2005-0170
 Application I. D. Number
 7/20/2005
 Application Date
 SFH Ballpark Drive Lot#3
 Project Name/Description

RE: Lot #2 Ballpark Drive - 371-A-032 - R-2 Zone - application #05-1010

RE: Application for Single Family House, Ball Park Drive, Lot 2, ID # 2005-0170

SITE PLAN
OF
LOT 2 BALLPARK DRIVE, PORTLAND, MAINE
MADE FOR
ANTHONY ORLANDO
57 SHEPHERD LANE, PORTLAND, MAINE

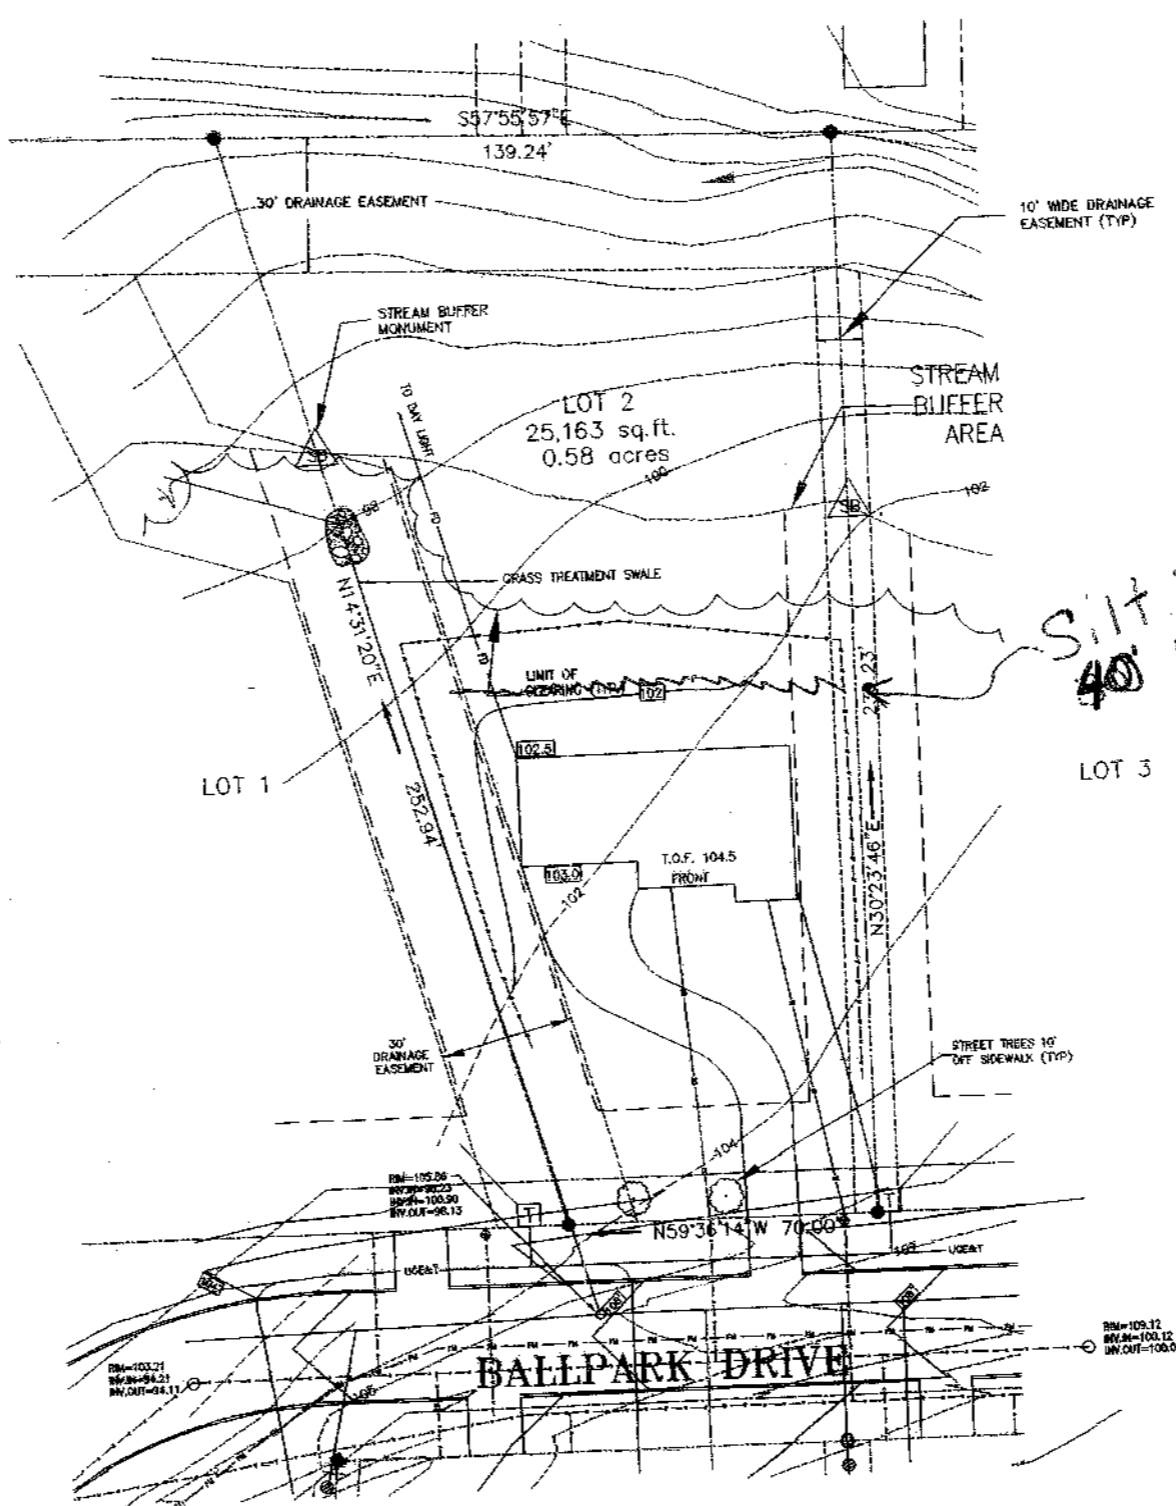
1. There is a 10' easement on your site plan that was not part of the Ball Park Subdivision. Please elaborate.
2. Please remove the foundation drain that falls within the stream buffer limit.
3. A sewer cleanout is required on sewer services greater than 80 feet from the sewer main. Please add a cleanout to the plan.
4. Reduced size/copy of site plan was not to-scale.
